APP
116 Miller Street
North Sydney NSW 2060

RE: Response to Government Architect Comments on HKH Stage 2 Redevelopment SSD

We have reviewed the issues raised in the Government Architect NSW independent design review commentary 15 December 2017. Our response is outlined below and reference made to the additional design information provided date 19 January 2018, Rev 01.

Level 1 MAIN ENTRY GA PLAN
1:100

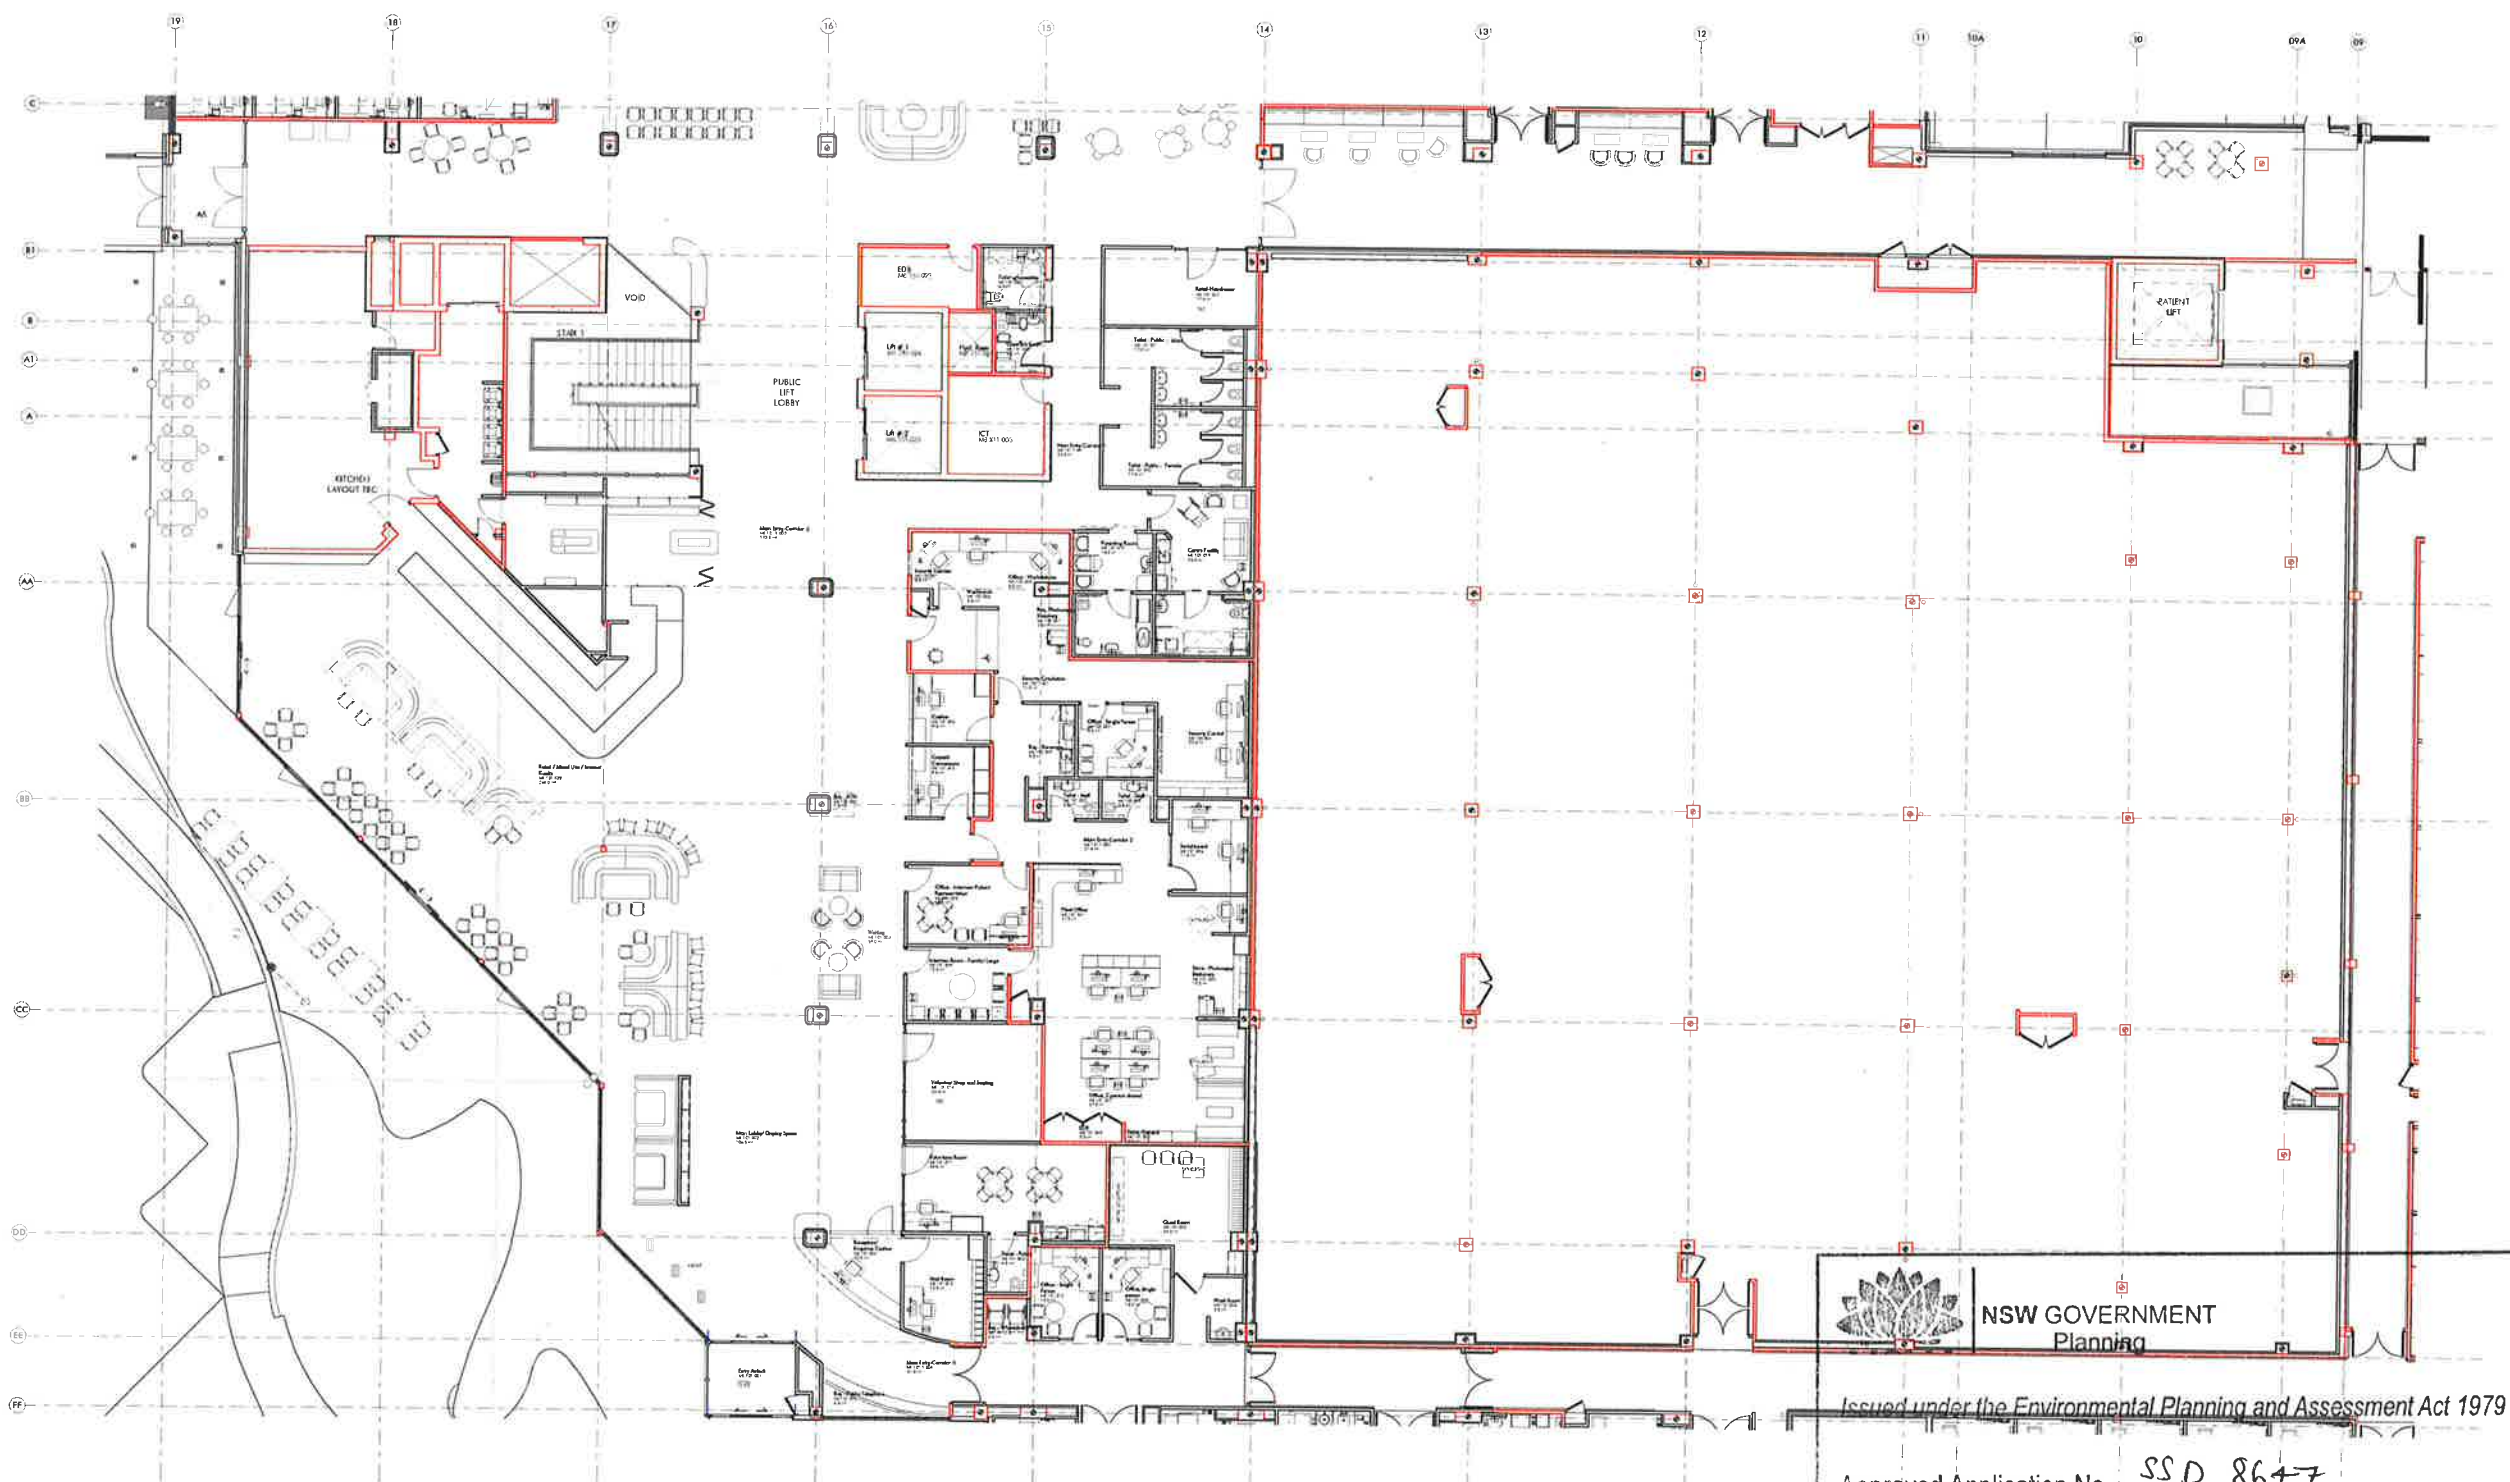
The main entry and emergency entry are both clearly identifiable from Palmerston Road from both a car and pedestrian approach. The priority at the entry has to be balanced between pedestrian and car, the requirement to get the car drop off point as close to the main entry doors as possible is to minimise distance of travel for less mobile people; many of the patients/outpatients are significantly less mobile.

Additional information has been provided to better describe all of the amenity that will be available in the hospital from the main entry doors, café, ambulatory care waiting area and the main street seating linking back to the STAR entry. Within the entry and public zones both internally and externally there is a significant number of seating.

The main entry 'waiting' seats at the main entry door overlooking the drop off zone to facilitate people waiting whilst a carer brings the vehicle to pick up. There are also some waiting chairs located directly outside the liaison office, also located only a few metres from the front doors and reception desk. Otherwise it is the overwhelming requirement of the hospital users that patients and relatives do not wait directly in the entry to the hospital.

There is a large café and seating zone within sight of the main entry and located in between the main entry and the main public lifts/stair. This provides a significant amenity to the hospital and the users. It should be noted that the design has separated the café use from the seating; whilst belong to the same space and visually connected it is the case the you do not have to be a customer of the café to sit in the seating area. This seating area also has a direct connection to the outside with more seating. The outside spaces also face north with large roof overhangs to provide significant shading during summer.

HORNSBY KU-RING-GAI HOSPITAL
STAGE 2
NORTH ELEVATIONS

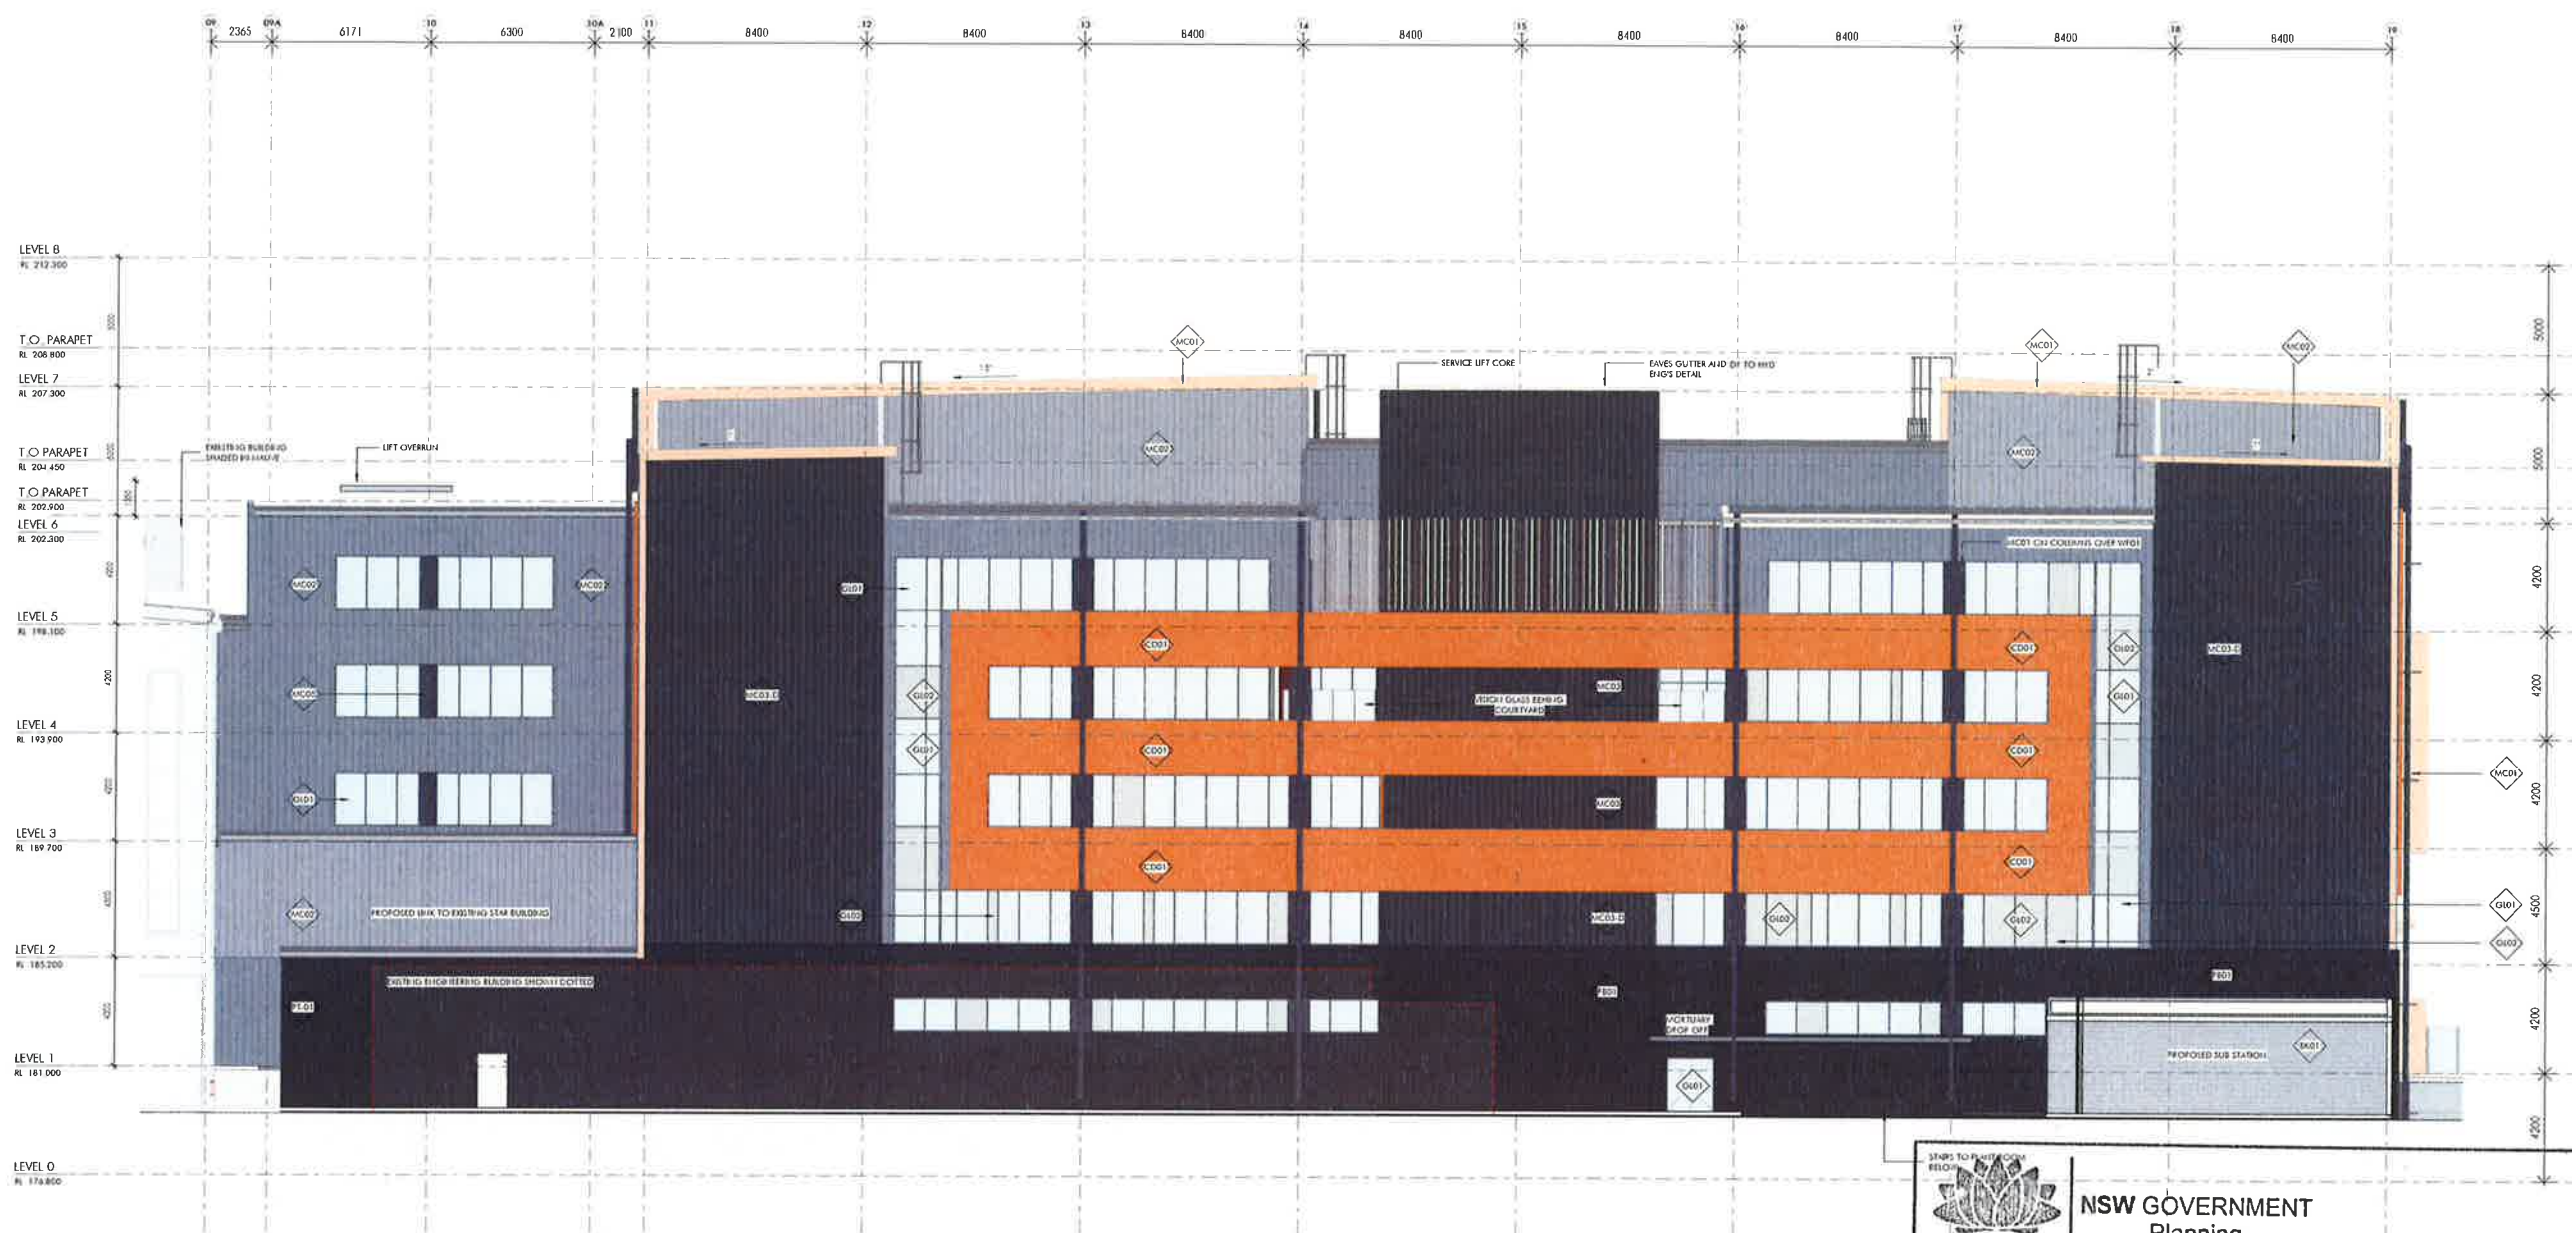
The terracotta aesthetic of Stage 1 has been echoed in the Stage 2 design to provide context and consistency to the hospital street frontages on Derby Road and Burdett Street. The scale of the Stage 2 building has increased on Derby Road. The terracotta band that provides that material connection also assists in reducing the visual scale of Stage 2. By continuing the brick podium and limiting the height of the terracotta material the visual scale of the building is broken into its elements. Further reduction of the mass is achieved by introducing cutouts, outdoor spaces at level 4, and stepping the plantroom and fire stairs back away from the street boundary where possible.
